BICESTERBUG

Submissions on proposed housing in NW Bicester

[21/04275/OUT](#)

21 February 2022

TITLE:
PROPOSED SIGNALISED JUNCTION

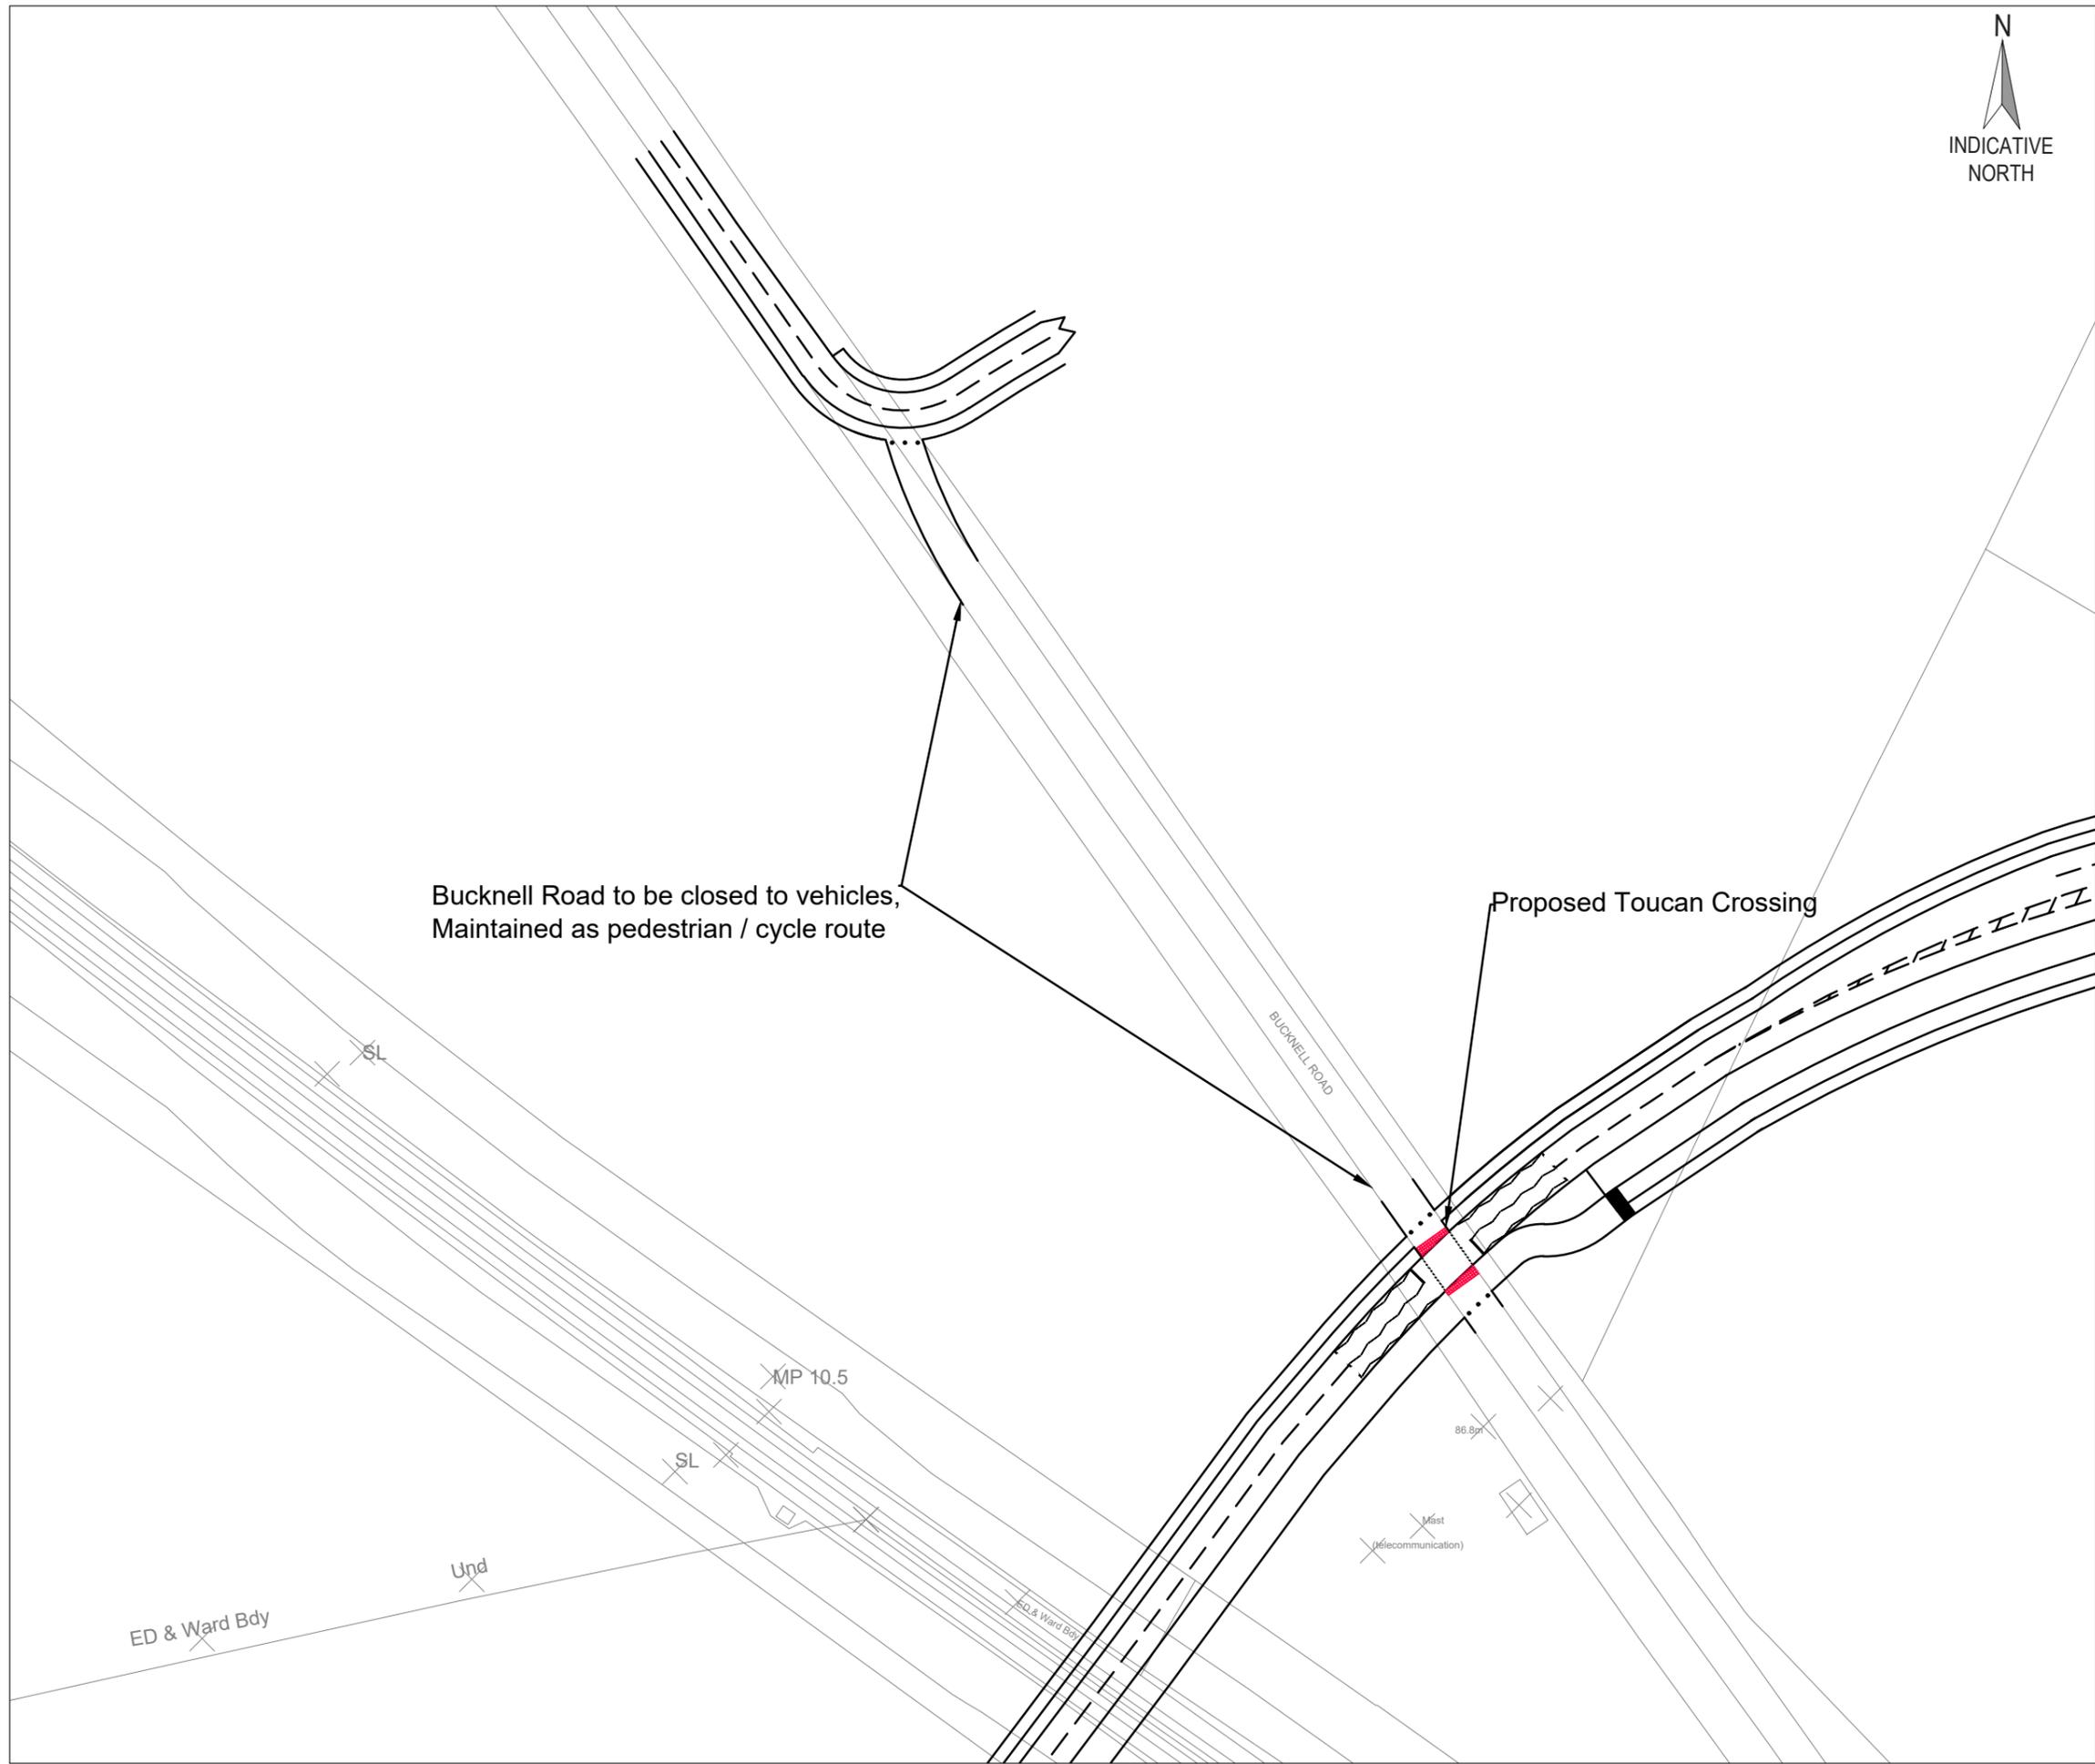
The proposed signalised crossing (File Ref 20300_SK_T_001(P3).pdf, Drawing Reference 20300 No 001) shows a legacy design that would not be suitable as an active travel junction. The shared path access routes and double stage signalised crossings are not in keeping with the level of ease of movement required.

A more straightforward Dutch style ‘simultaneous Green’ junction, as recently implemented at various locations in Walthamstow, London would be a much better solution. See for example:

Key points for the ‘simultaneous green’ are that there is a single phase for walking and cycling where all traffic flows are held, followed by two motor vehicle phases. Capacity can be adapted as appropriate depending on need by interposing the simultaneous green between each motor vehicle phase, or skipping it entirely if there is no demand. Cyclists remain on the paths closest to the traffic at all times.

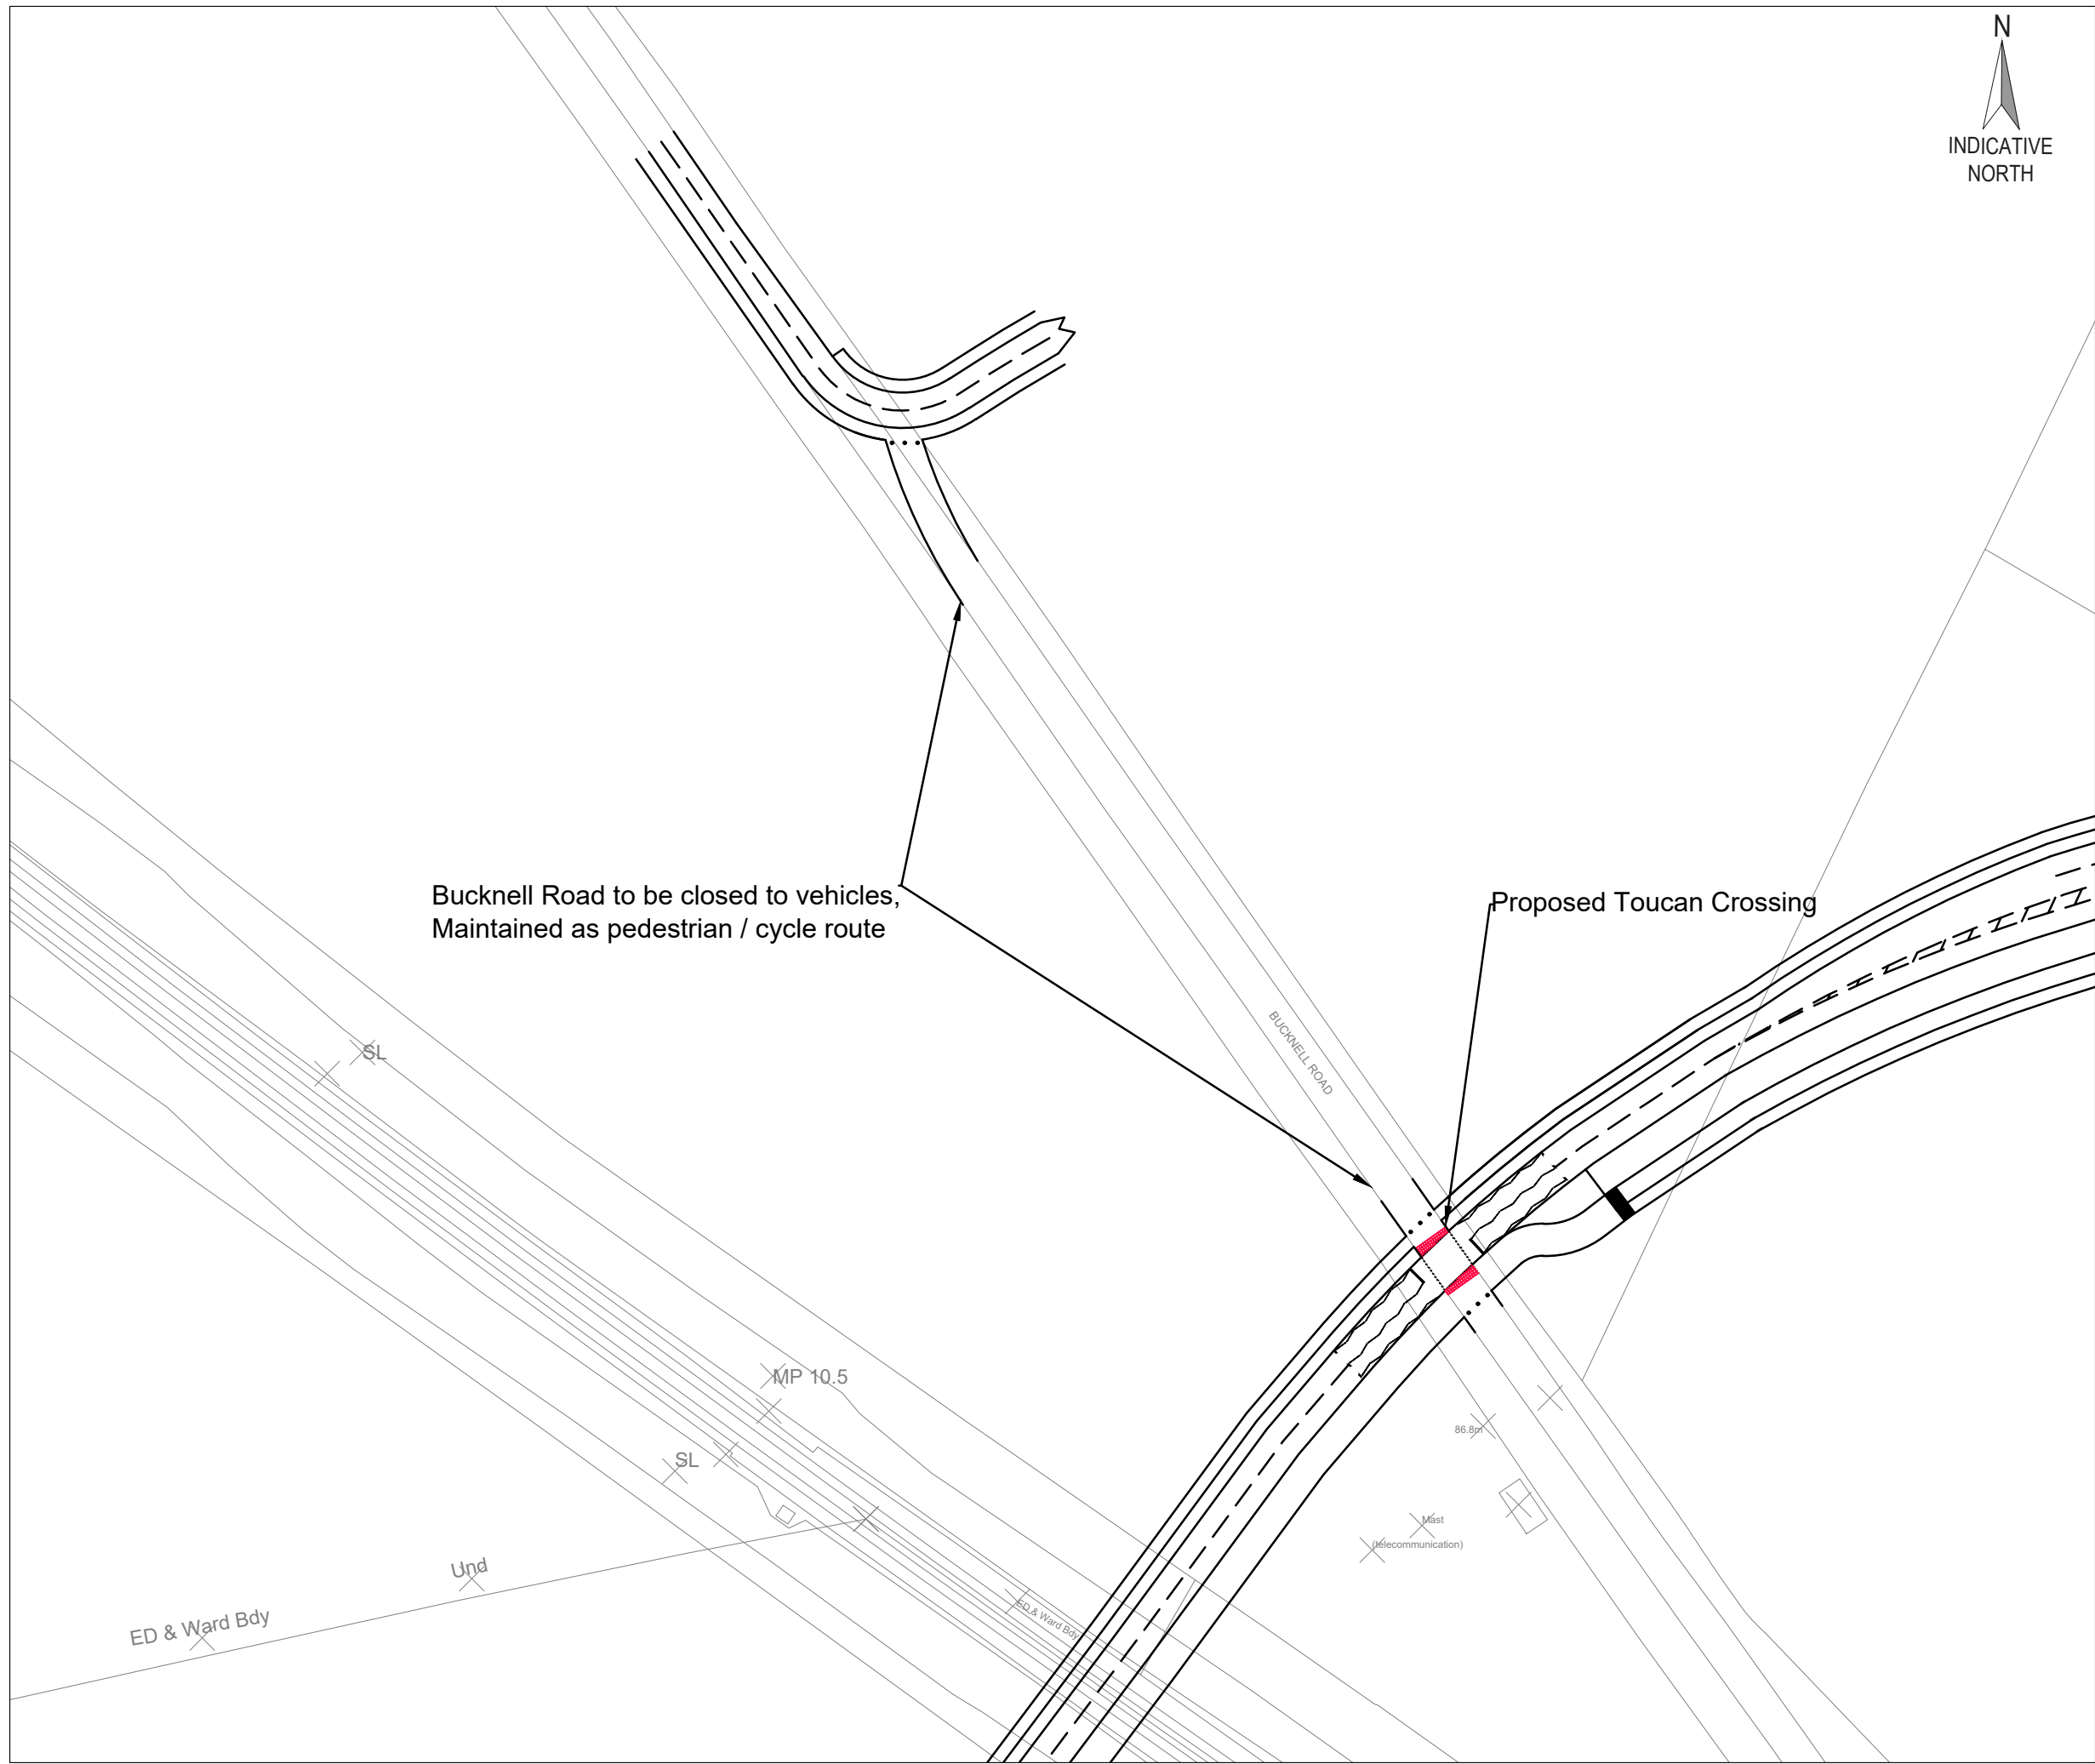
The proposed cycling and walking connection using what is the current Bucknell Road is a welcome addition. It is worth noting that the cycle provision on Bucknell Road south of the indicated crossing is poor and well below current standards (<1m wide painted cycle paths for some sections) and the pavements are narrow. For the connection in the drawing to be usable to access Bicester facilities then Bucknell Road needs also be improved and brought up to LTN1/20 standards with segregated provision, buffers, and priority.
